February 12, 2020

SH83/Walker Rd
El Paso County

re: Monument Academy - Feb/2020 - Update Site Dev Plan and CDR (Road and Roundabout)
REVISED Hydraulics and Traffic Operations comments:

SITE DEVELOPMENT PLAN

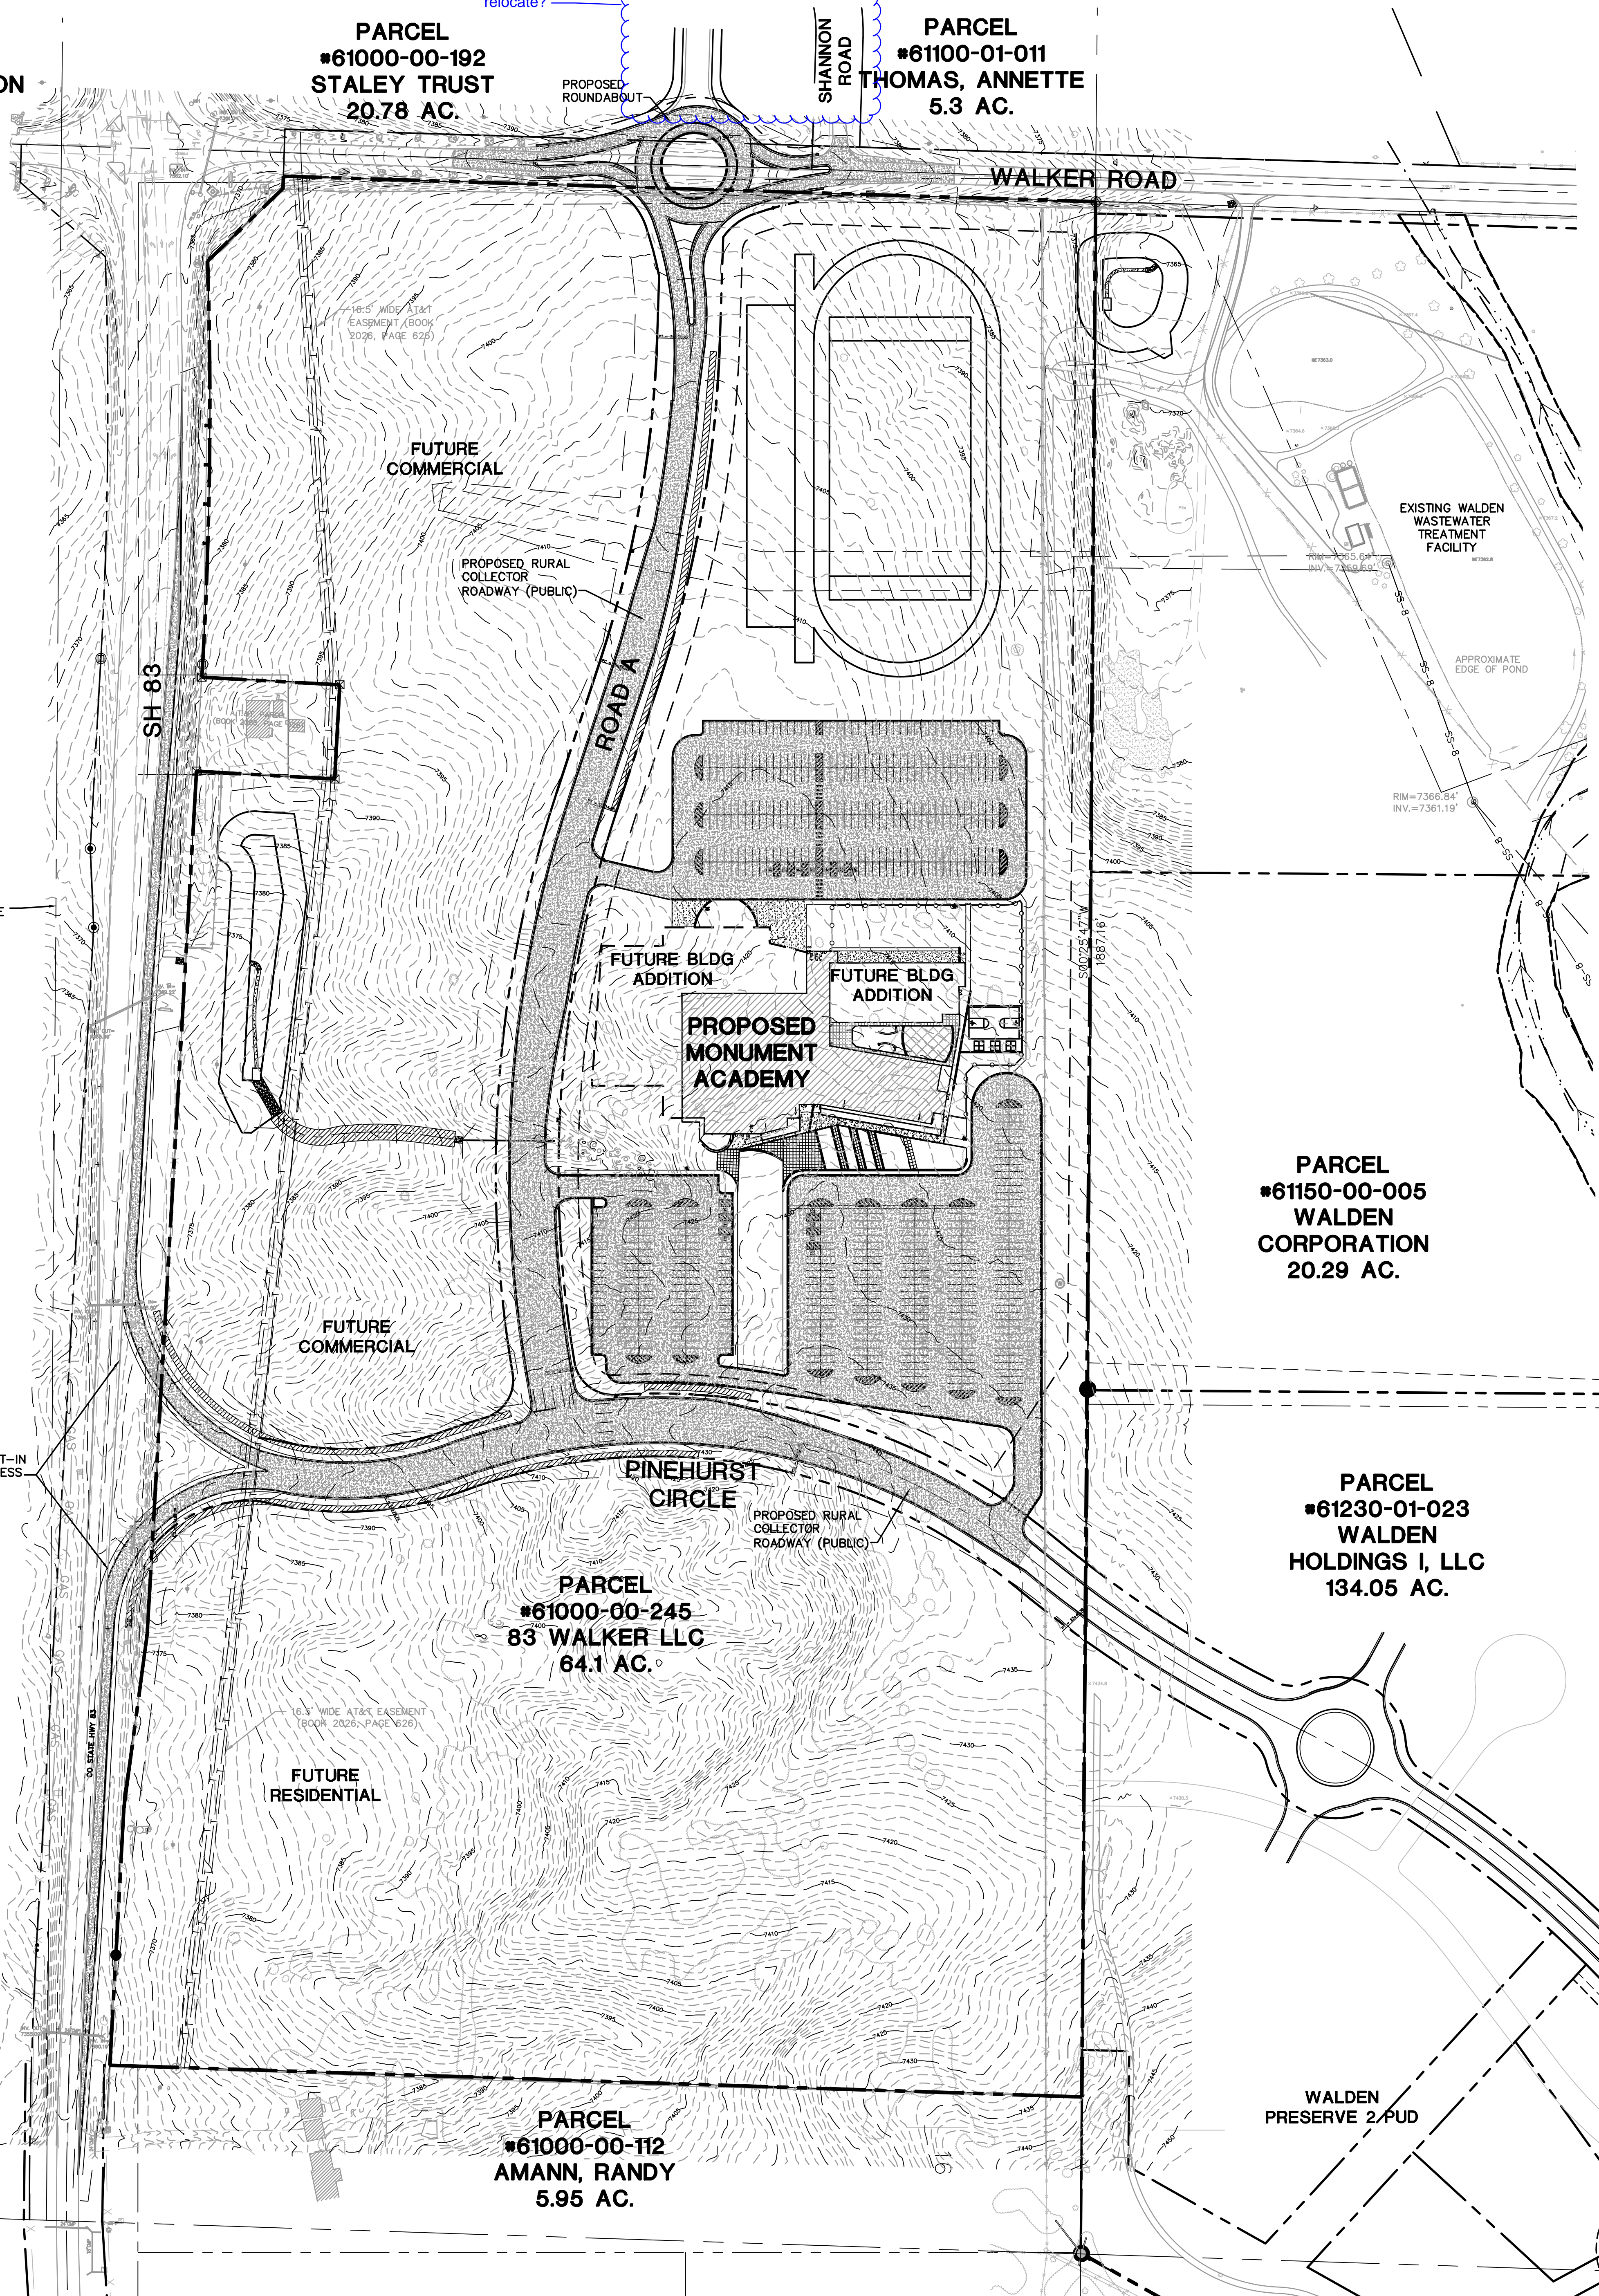
- e. Right of Way donation designated as CDOT future public right of way will need to take place to preserve the ultimate configuration of the future 4 lane principle arterial roadway along the west boundary of the development. This is not detailed in the Site Plan, **please revise**

ENLARGED DETENTION POND M3 PLAN

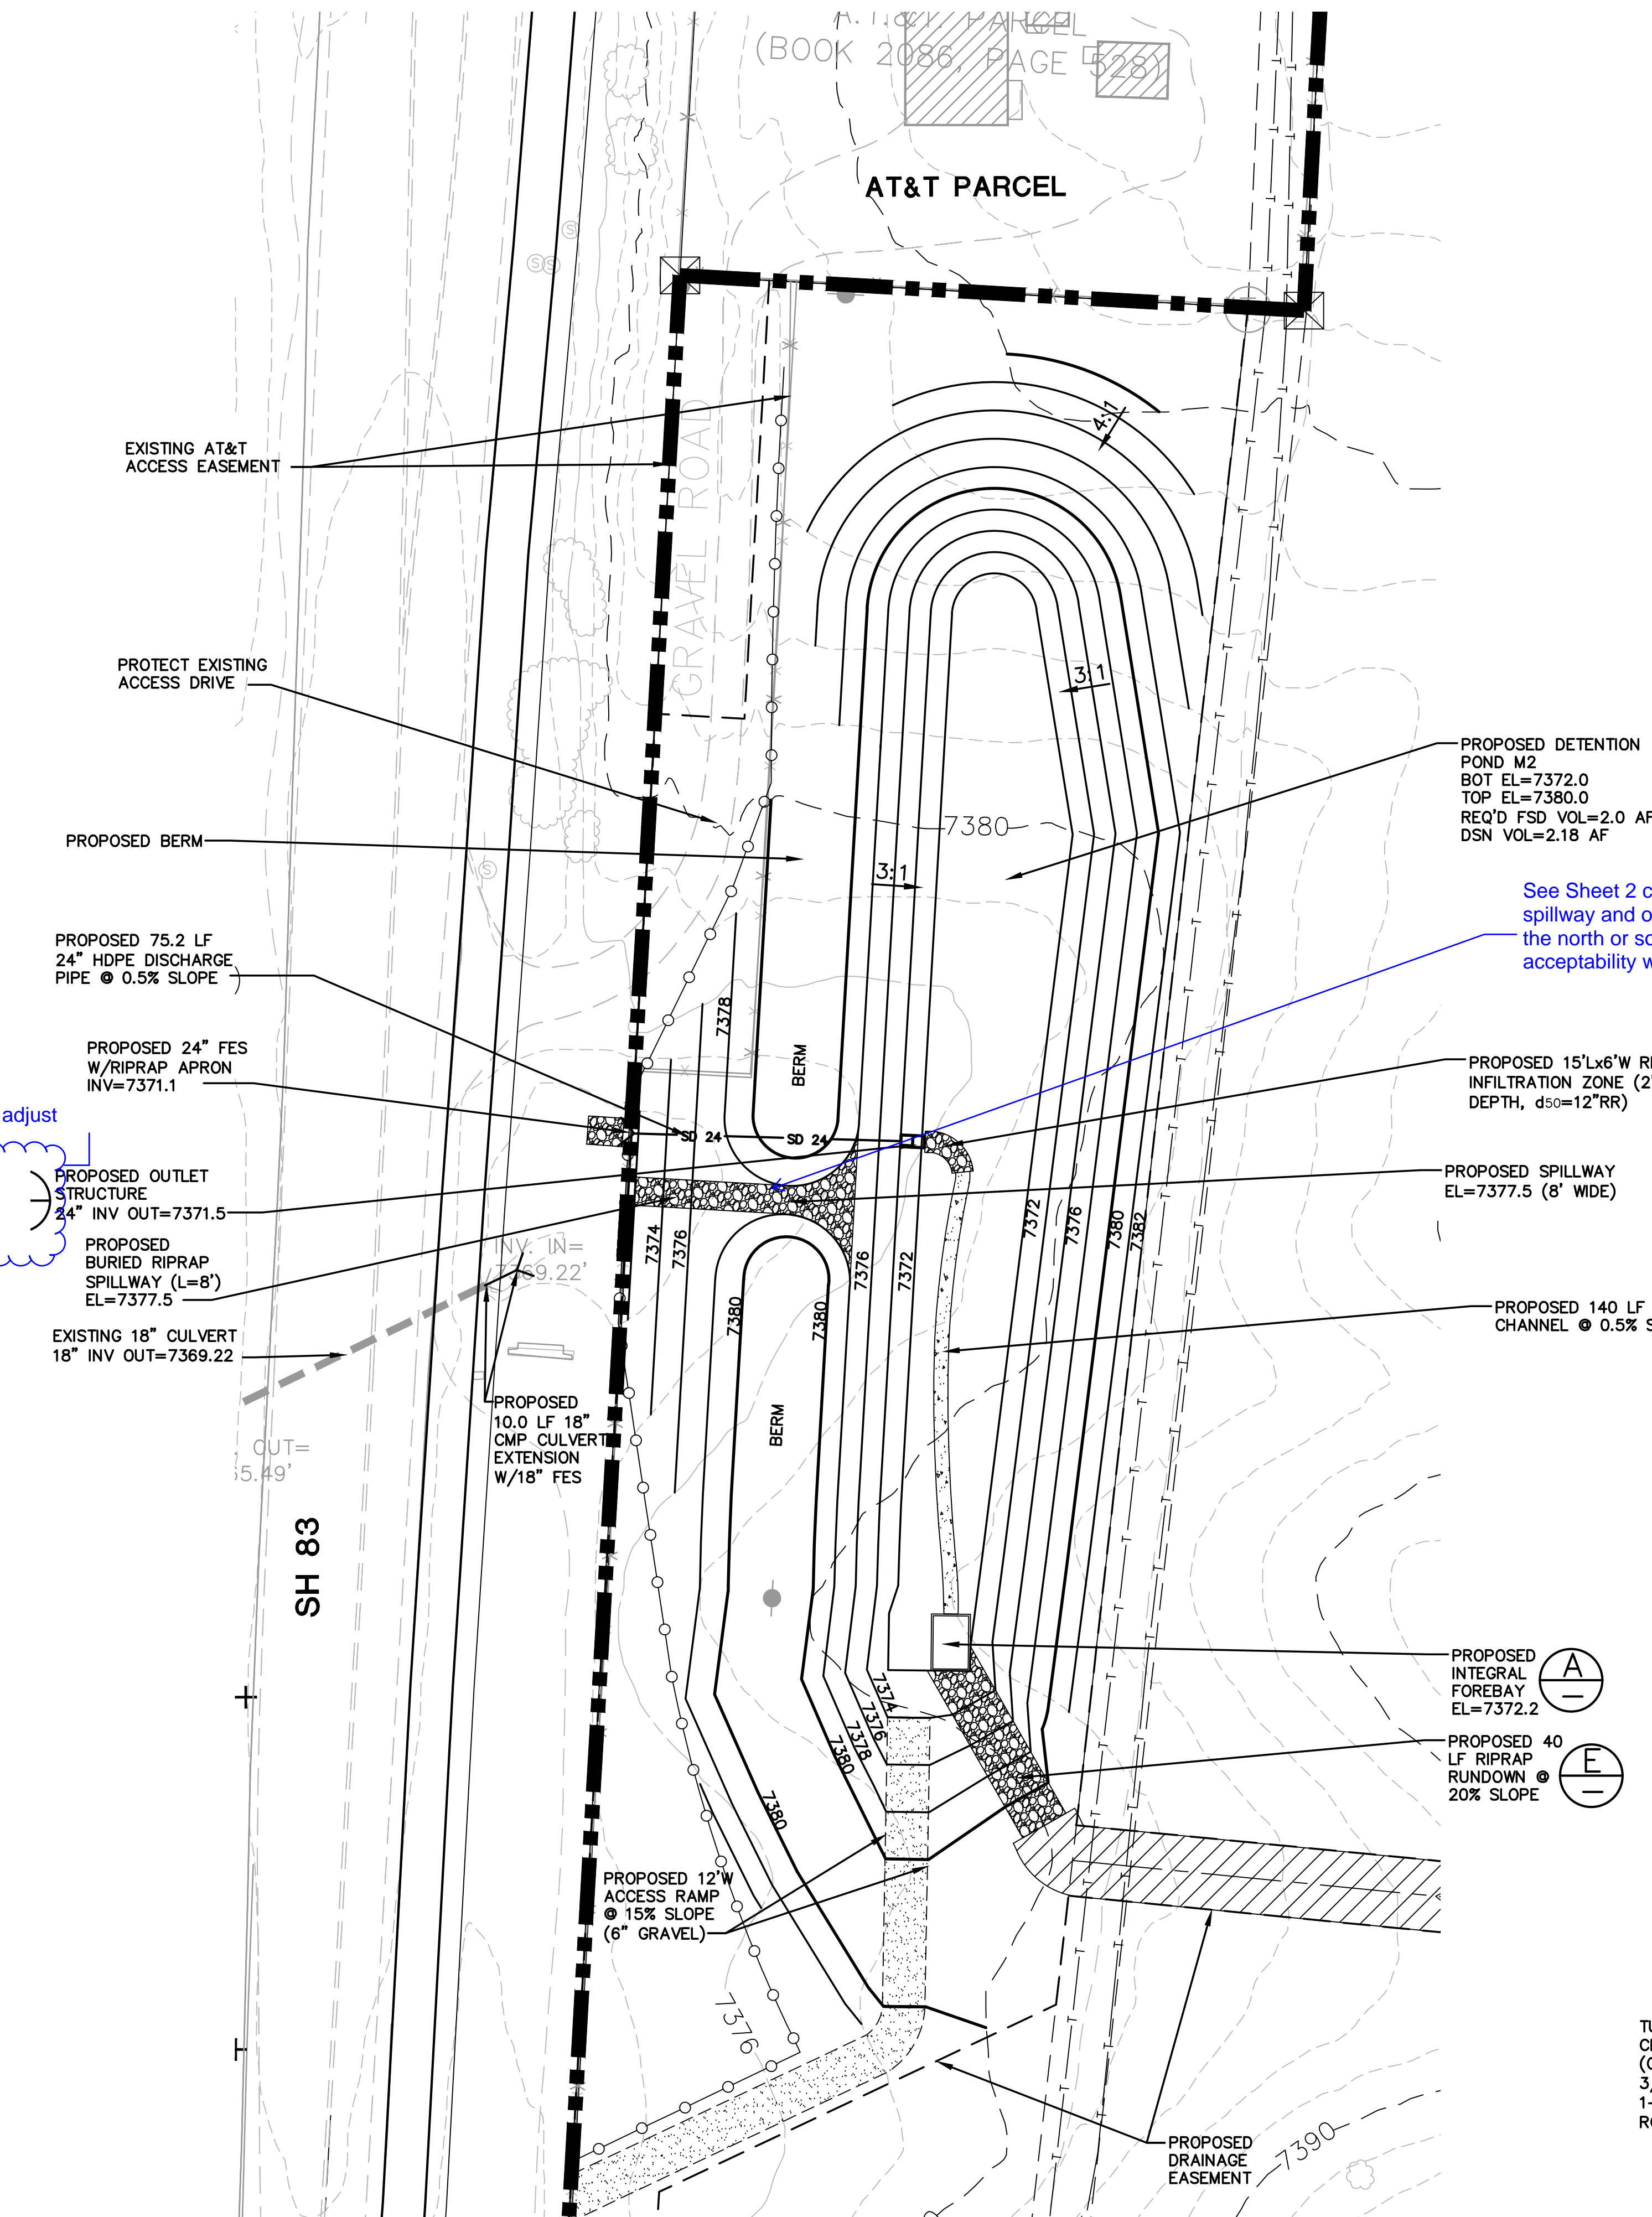
- a. Comments are from the review of Master Development Drainage Plan & Final Drainage Report, dated February 8, 2019 (Revised July 12, 2019), prepared by JSP Engineering.
- b. **Extend** proposed riprap at outlet of Pond M3 to connect to the new extension of the existing CDOT cross culvert, **please address and communicate back to CDOT.**
- c. Include in the construction work, clean existing 24" culvert that receives outflow from Pond M3, **please address and communicate back to CDOT.**
